23 Ocean Avenue – 4 residential units, app. 2,400 SF office (updated 9/22/16)

LEVEL III SITE PLAN REVIEW (14-526)

SUBDIVISION REVIEW (14-497)

SITE/SUBDIVISION PLAN (PRELIMINARY) OF 23 OCEAN AVENUE PORTLAND, MAINE
FOR RECORD OWNERS: STEVEN E. AND ROBERTA S. COPE
FOUR POINTS ASSOCIATES, INC.
Donald E. Dostie PLS, Principal
9 Ralph Avenue, Lewiston, ME 04240 Tel. 207-577-5840

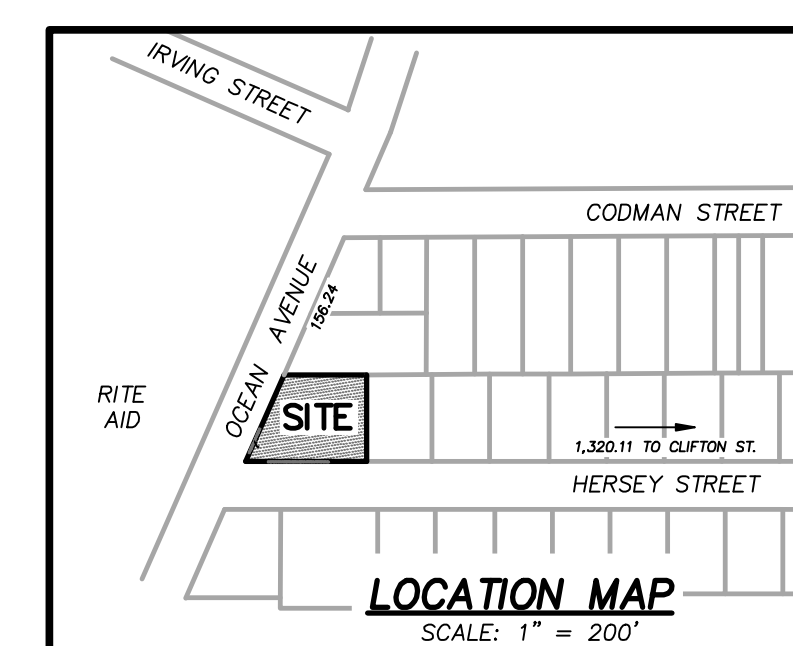
Show licenses with referend to footing?
 Show zone line
 Include reference to parking arrangement (off-site parking to meet requirements of Division 20, any shared parking arrangement)
 Update ramp alignment at Ocean/Hersey pending discussion on design w/ DPW

Footings & cornice in ROW

Public pedestrian easement will be required for sidewalk which encroaches on private property

**SITE PLAN**

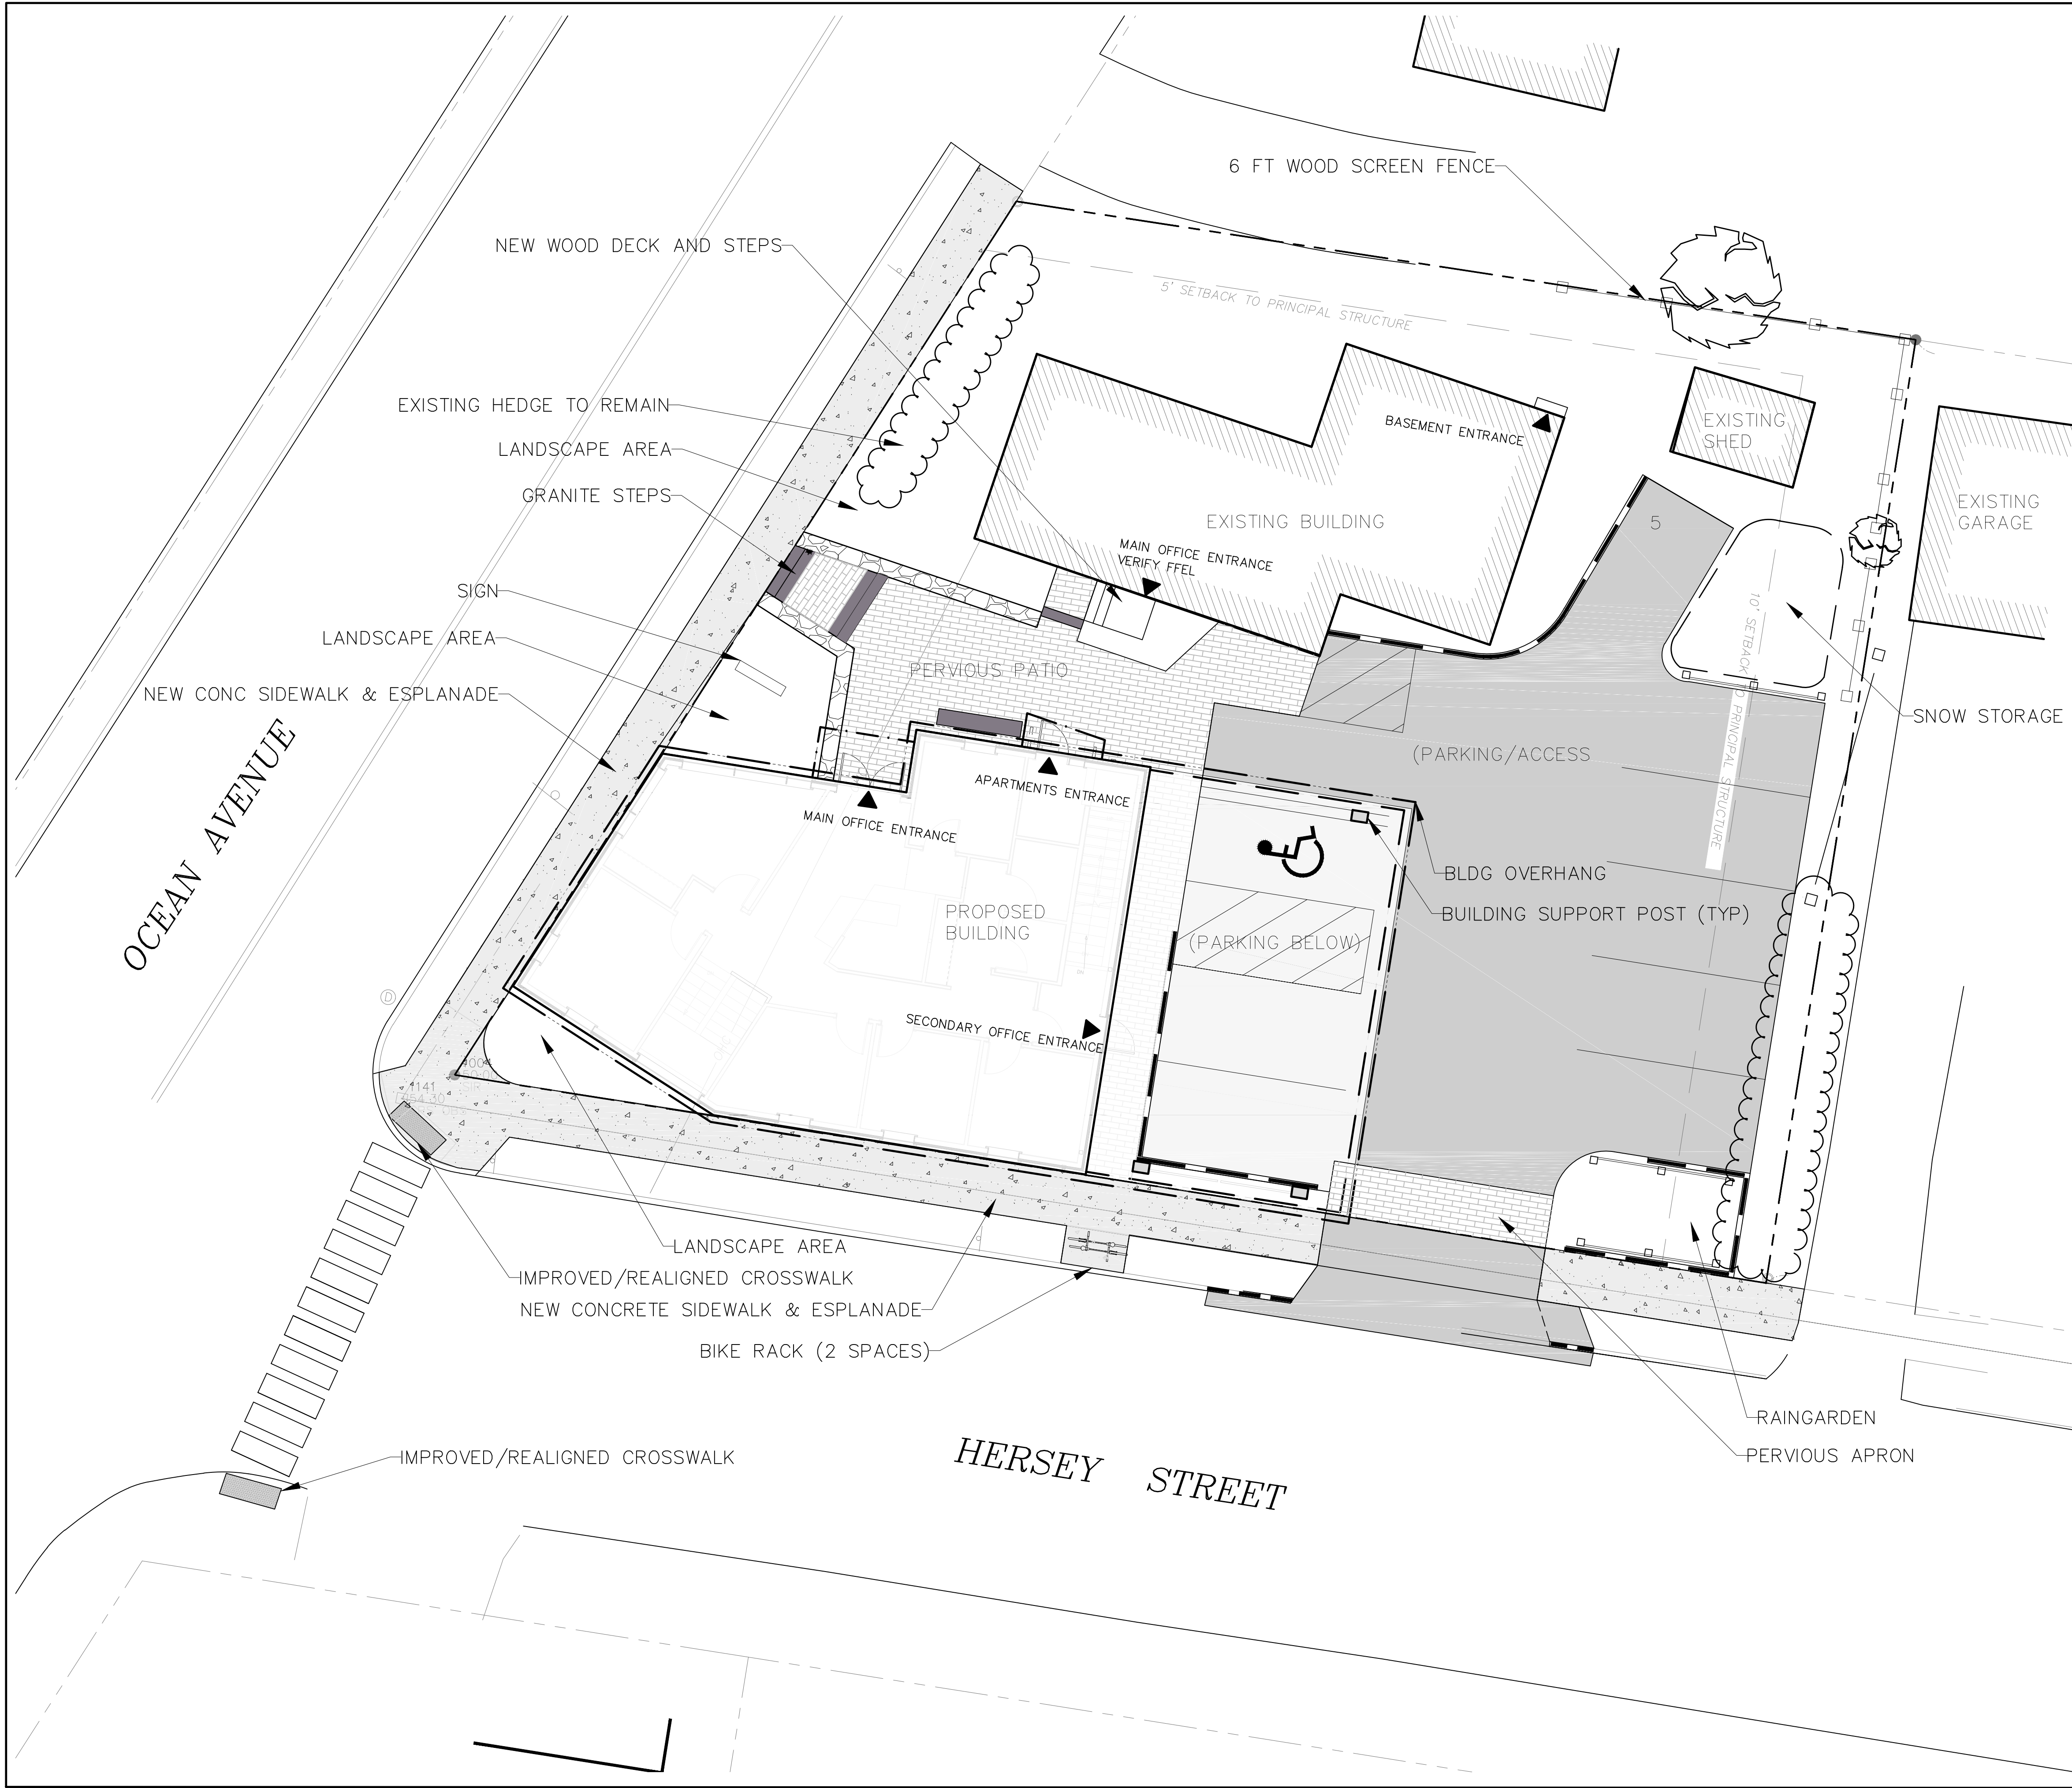
Preliminary Review
Transportation	a. Impact on Surrounding Street Systems	•
	b. Access and Circulation	<ul style="list-style-type: none"> • Sidewalk should be reconstructed along entire length of Ocean Avenue frontage • Please document ADA accessibility from the street

e. Transportation Demand Management (TDM)	•
Environmental Quality	a. Preservation of Significant Natural Features	•
	b. Landscaping and Landscape Preservation	<ul style="list-style-type: none"> • Consider additional evergreen landscaping on eastern property line where site abuts residential zone • Cherry and F-basin conflict

b. Shadows	•
	c. Snow and Ice Loading	•
	d. View Corridors	•
	e. Historic Resources	•
	f. Exterior Lighting	• Provide an exterior lighting plan in the revised submittal
	g. Noise and Vibration	•
	h. Signage and Wayfinding	
	i. Zoning Related Design Standards	• Orientation/Door on street!

A	SITE PLAN PERMITTING	6-6-16
No.	Revision/Issue	Date
Design by:	JIM	Checked by: SJB
Drawn by:	JIM	Approved by: SJB
Project:	161.06035	
Sheet No:	C1

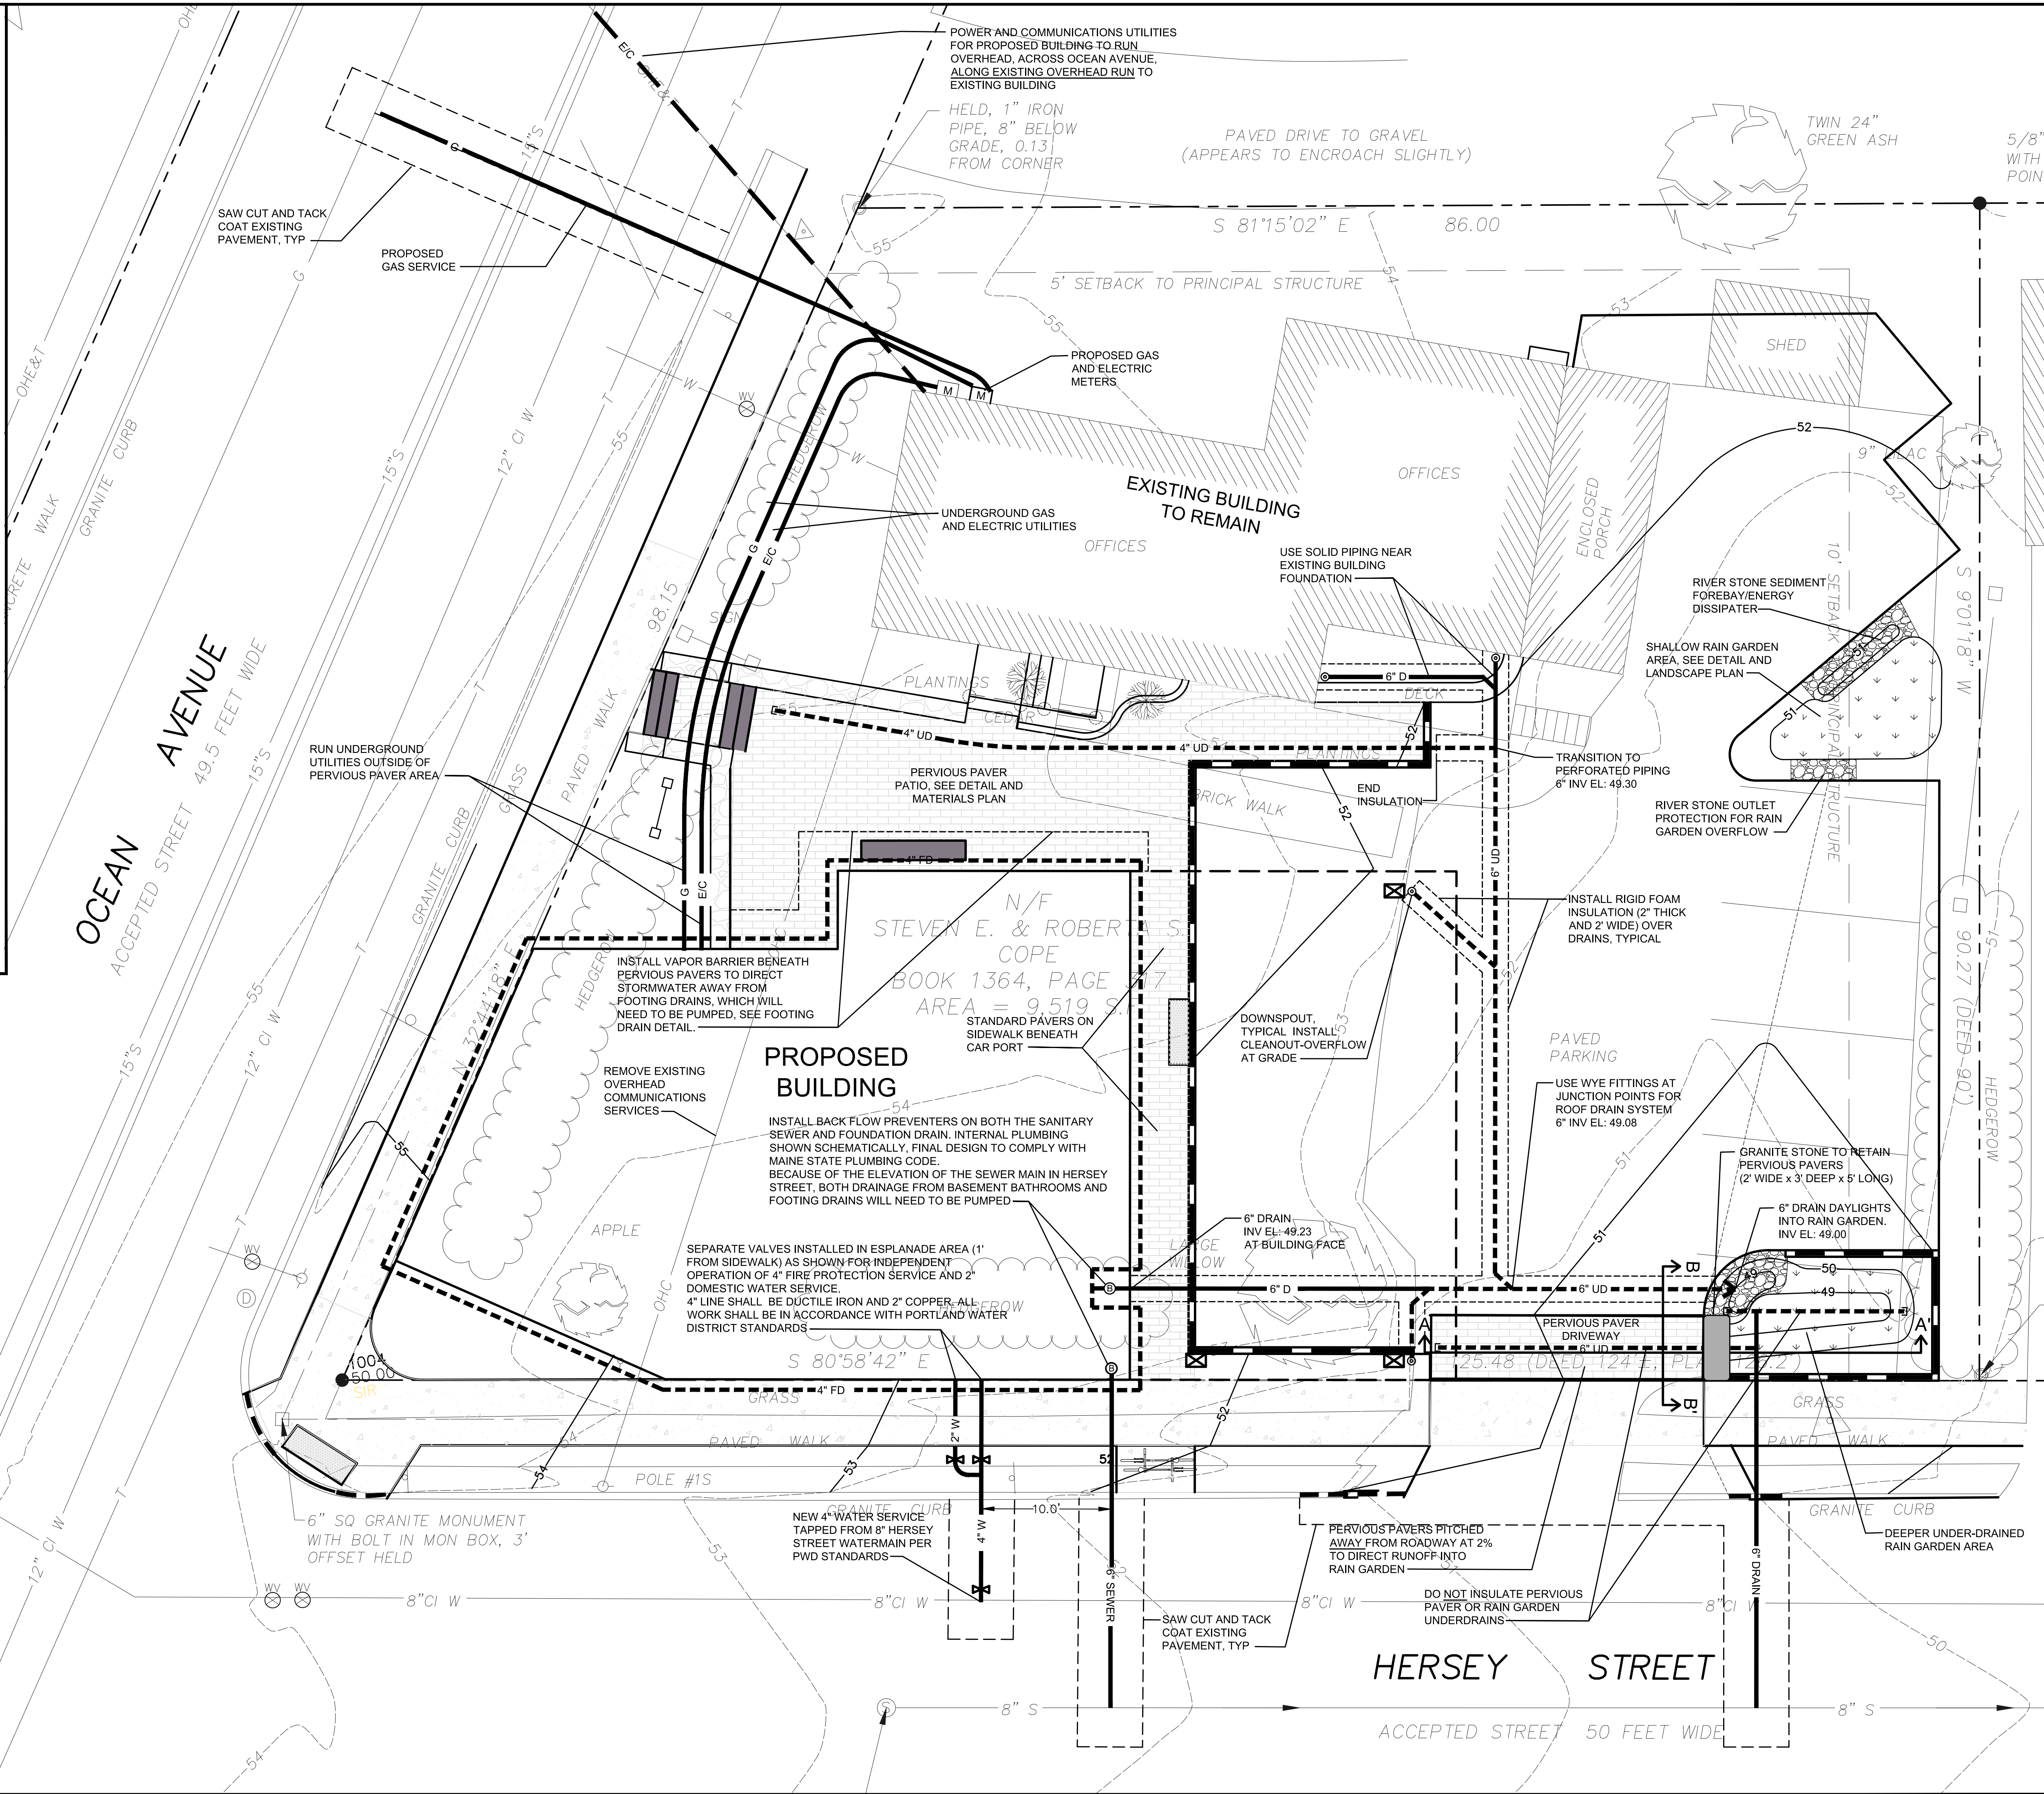
c. Availability and Adequate Capacity of Public Utilities	<ul style="list-style-type: none"> • Overhead electric is not permitted. Please confirm a plan for underground electrical with CMP Modified electrical to provide underground from across Hersey. Will confirm notes are okay with DPW. • Will be condition of approval around potential for removing pole.
Site Design	a. Massing, Ventilation and Wind Impact	• Where is HVAC venting? Roof mounted
